Your Ref: OWPC16698
Our Ref: FG/115/17/PL 17-07-2017
Please ask for:
Mrs A Gardner

4 No. bungalows
44 Ferringham Lane Ferring

Thank you for your internet representation made on 20th December 2017 which has been recorded as '**an objection**' with the comments as follows:

Elevations

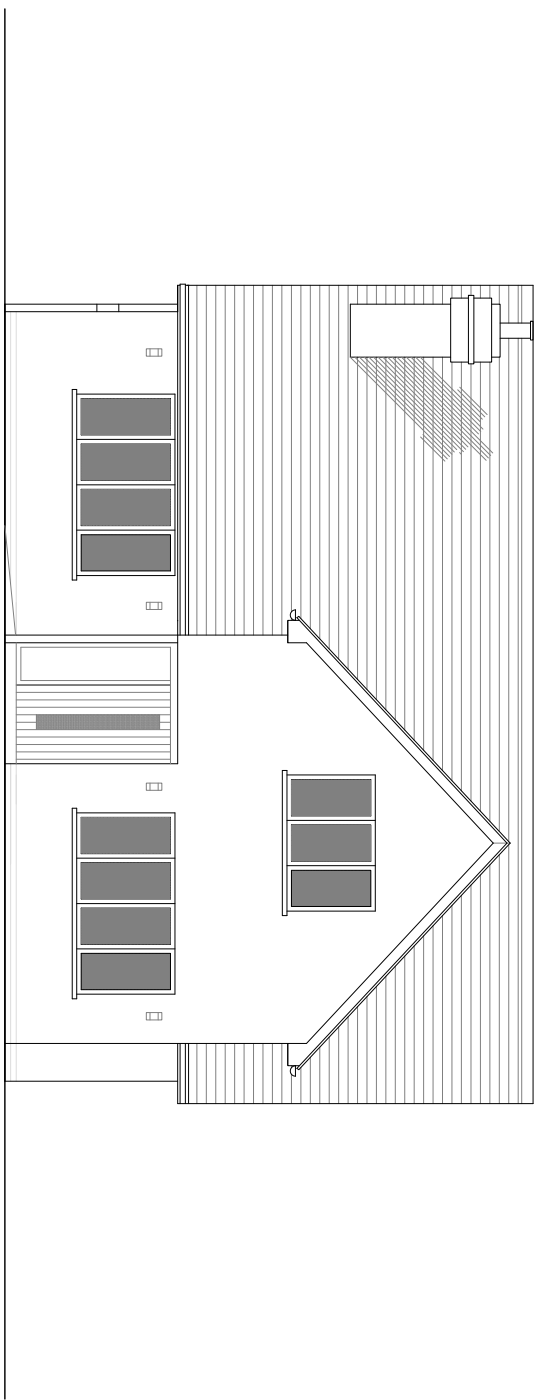
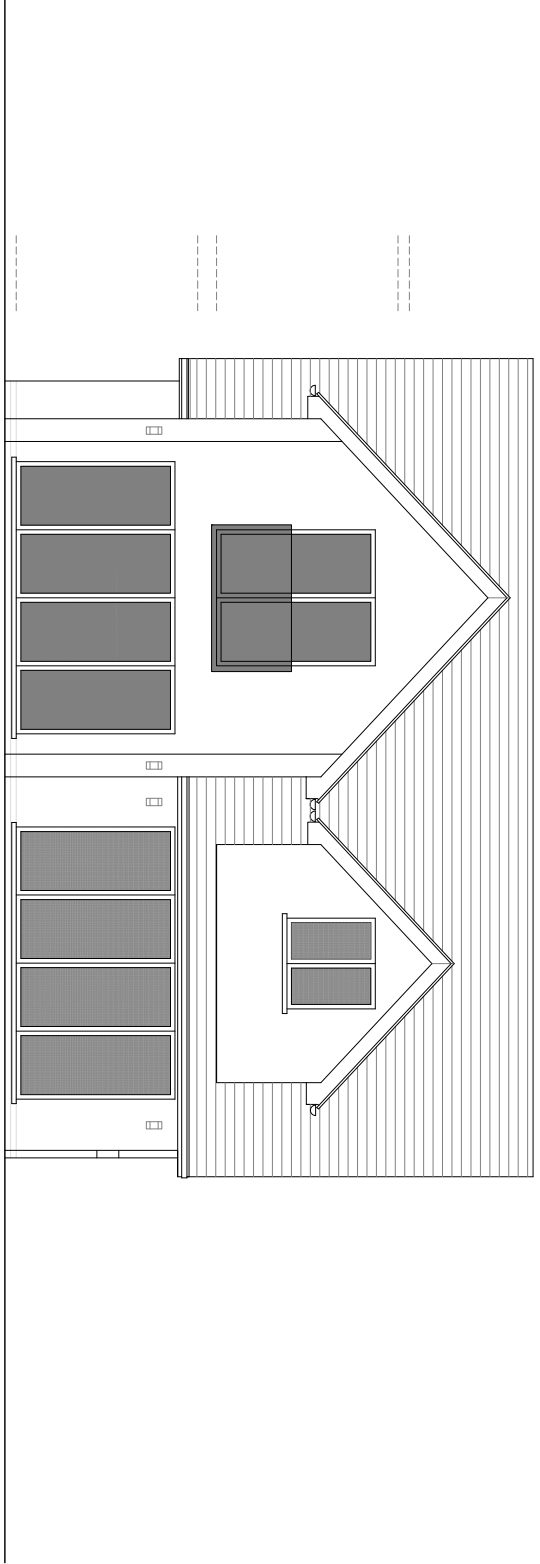
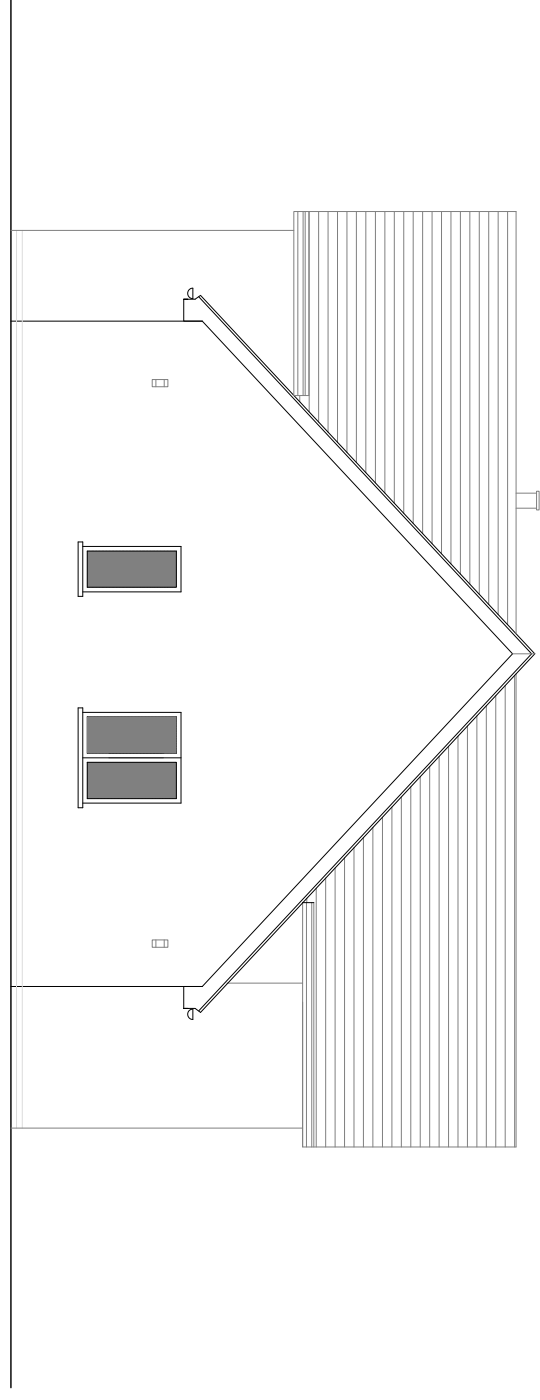
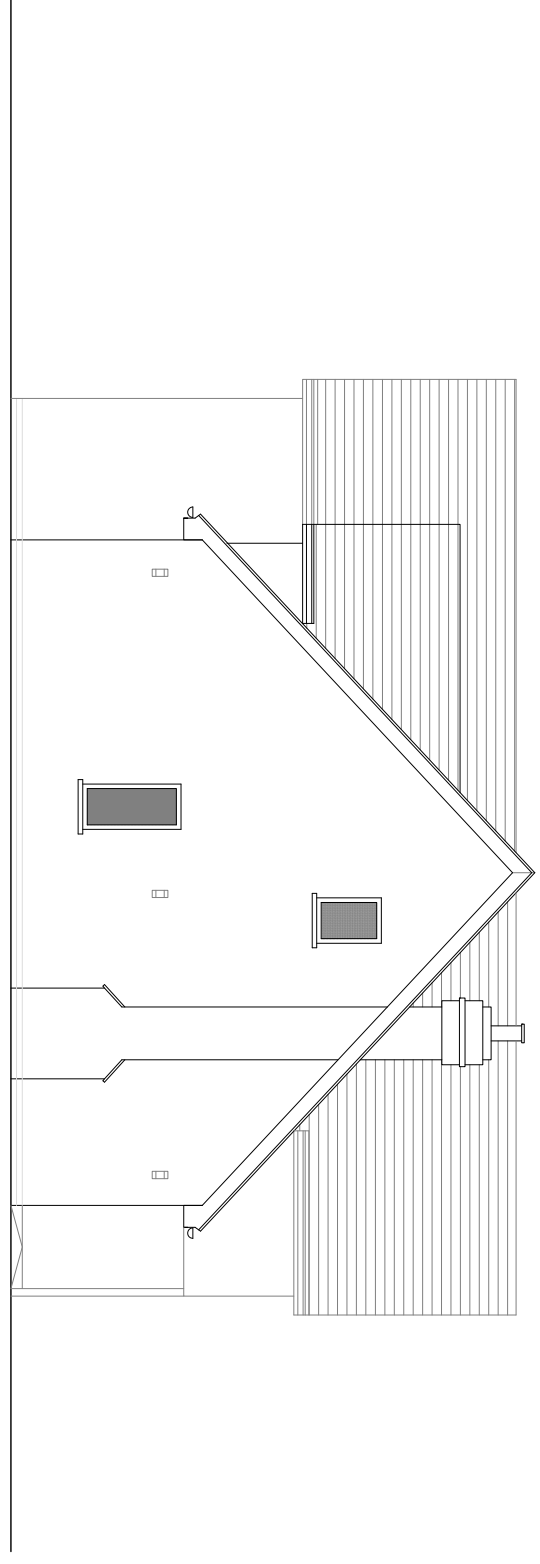
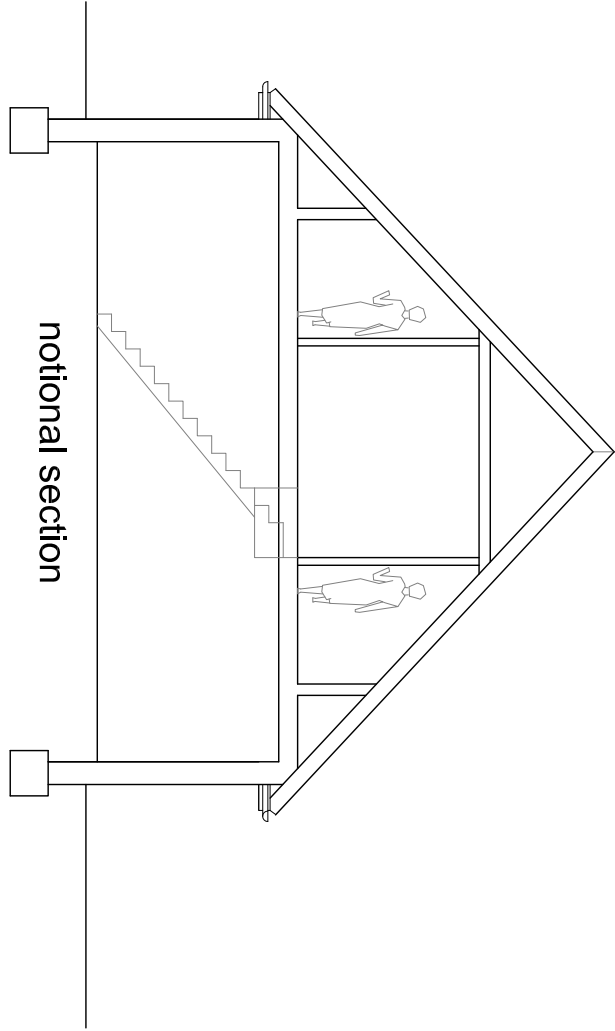
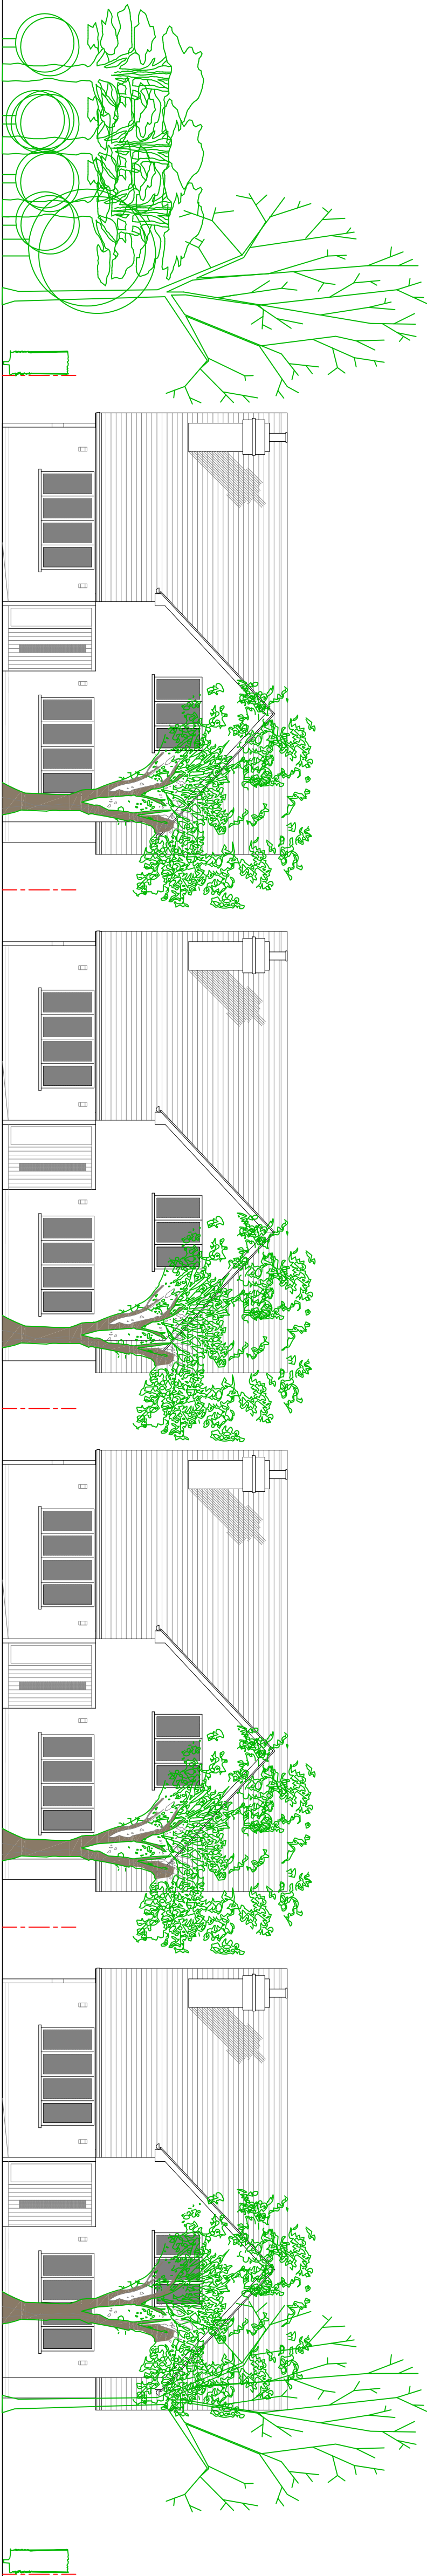
Secondly, I note that the permission granted on Appeal is to build 4 bungalows, whereas the plans now appear to show 4 two storey houses, which may result in overlooking of neighbouring properties.

Rooft plans

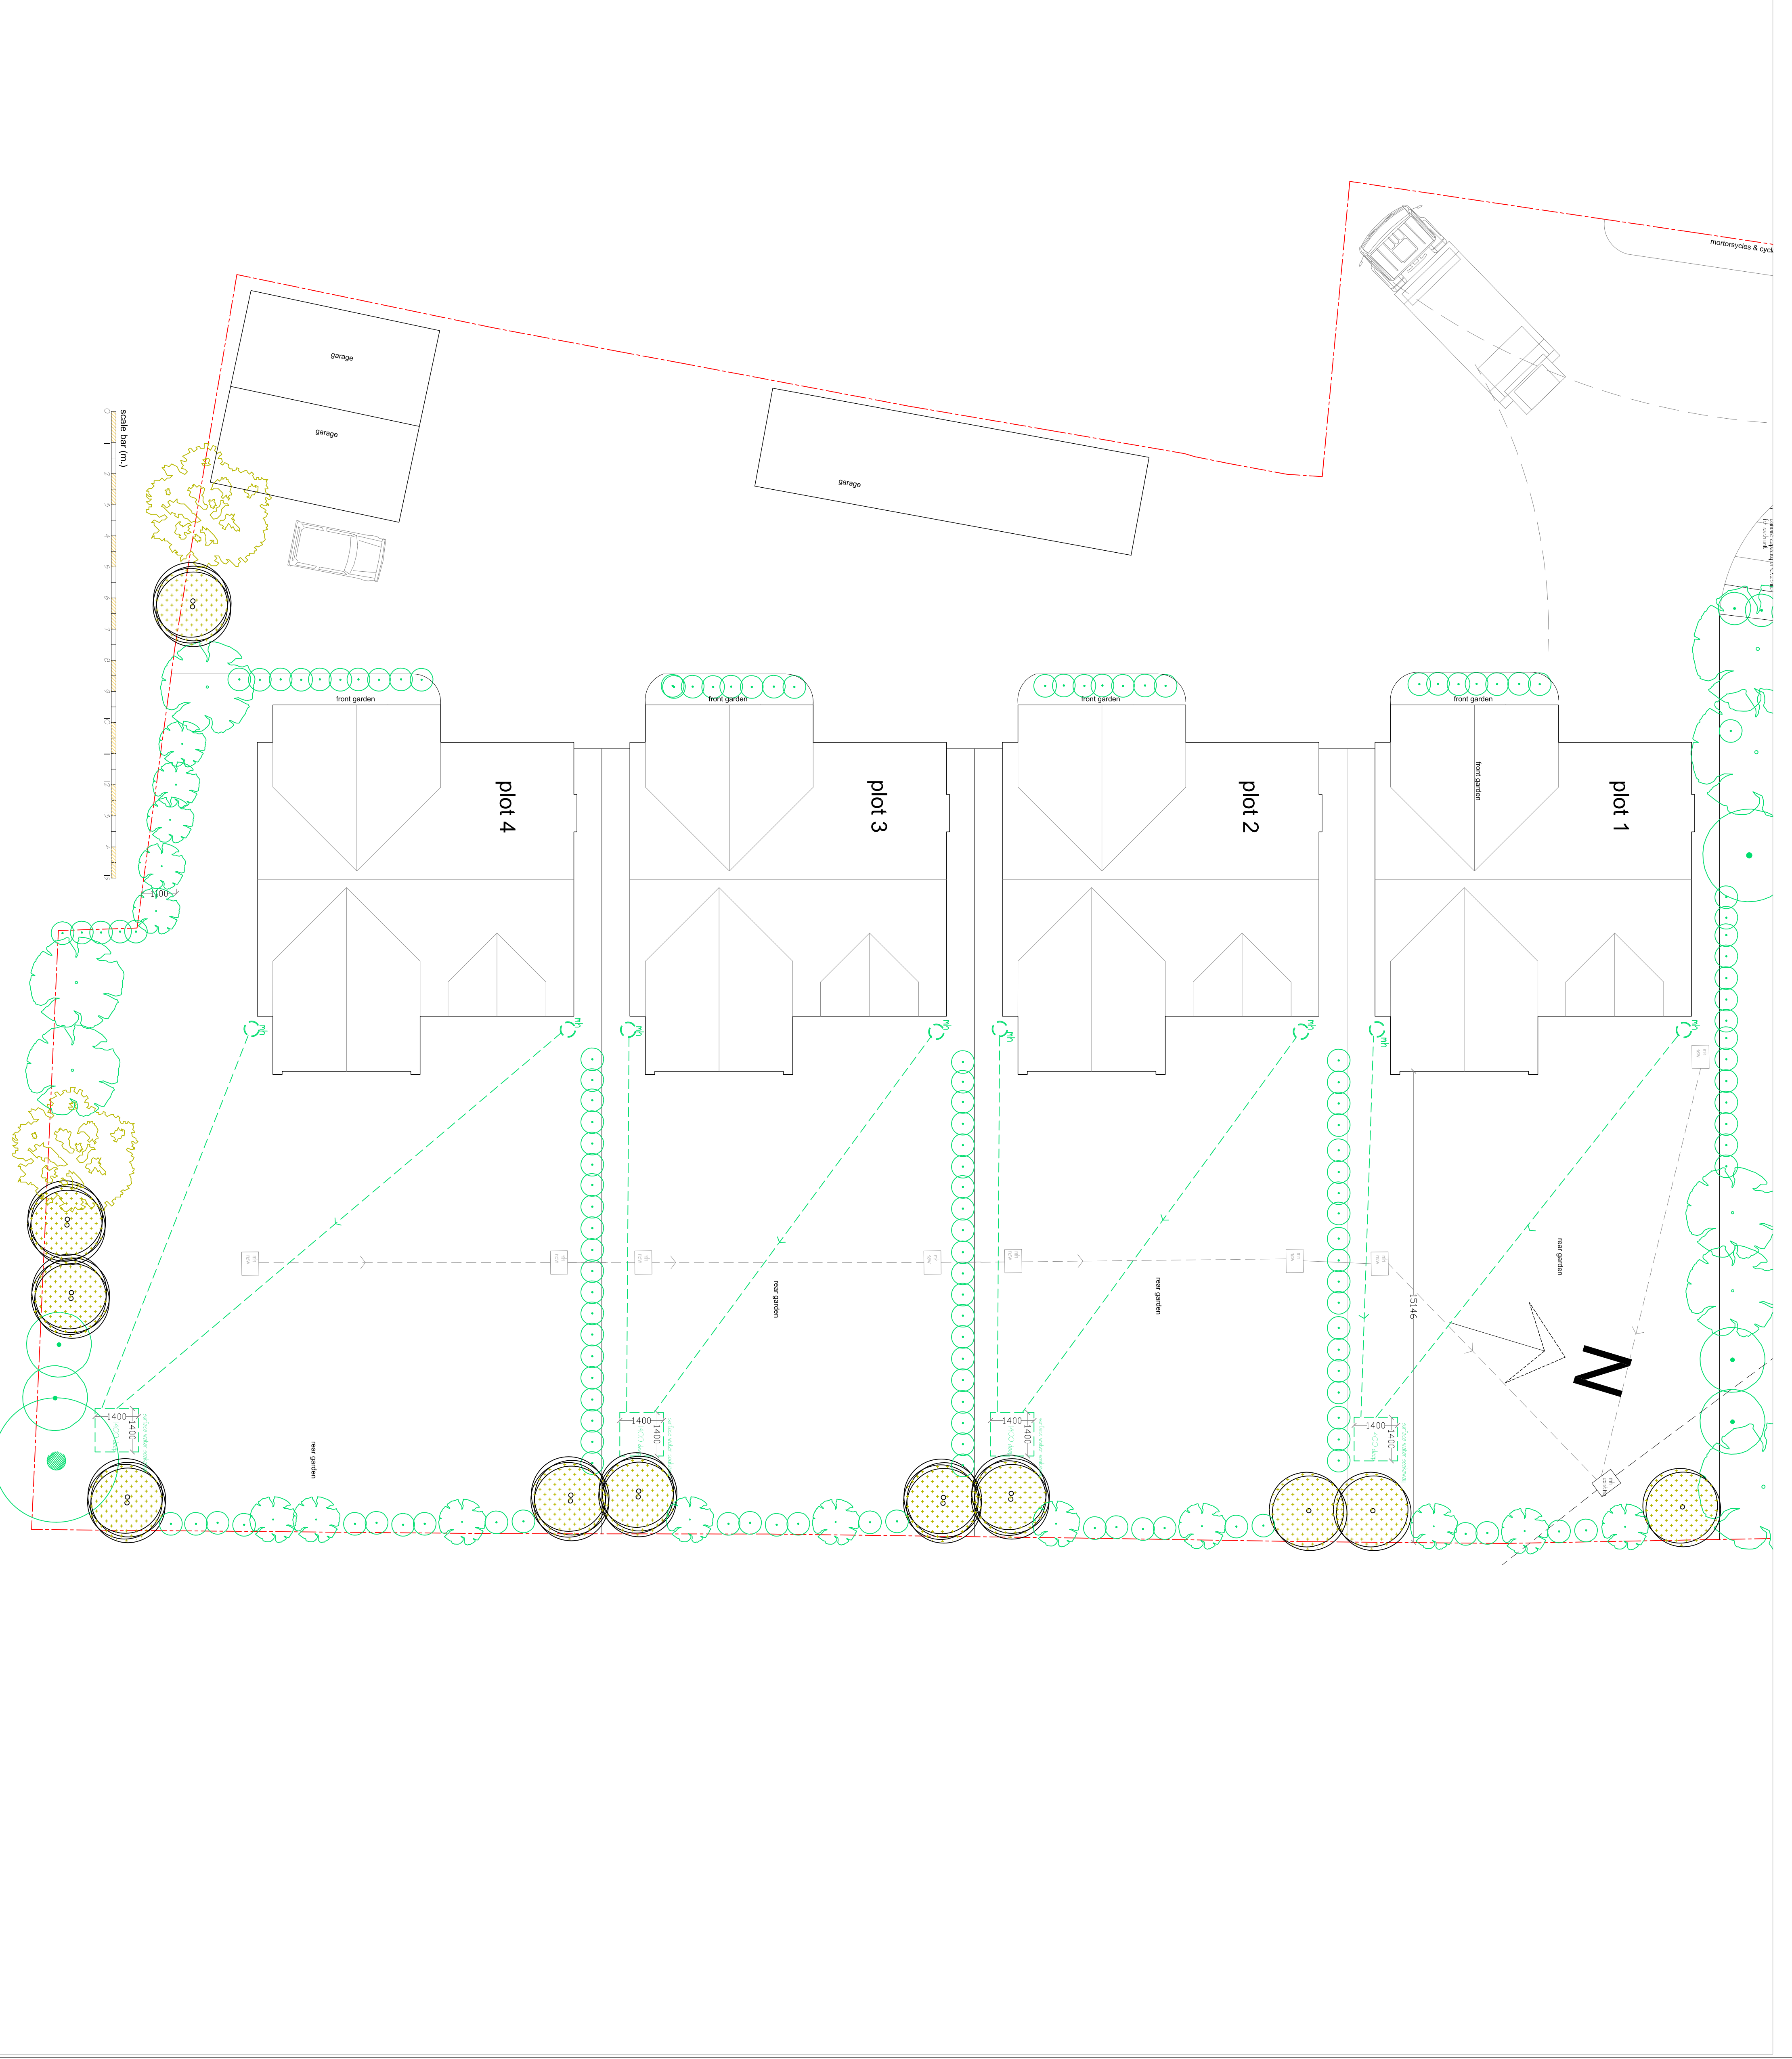
My previous comments stand regarding a duty of care owed to Villagers, road users and pedestrians by the Planning Committee in respect of ensuring that the Conditions that were imposed in granting this Application on appeal are fully implemented so as to ensure road safety. Unfortunately, the access to this site is still too narrow.
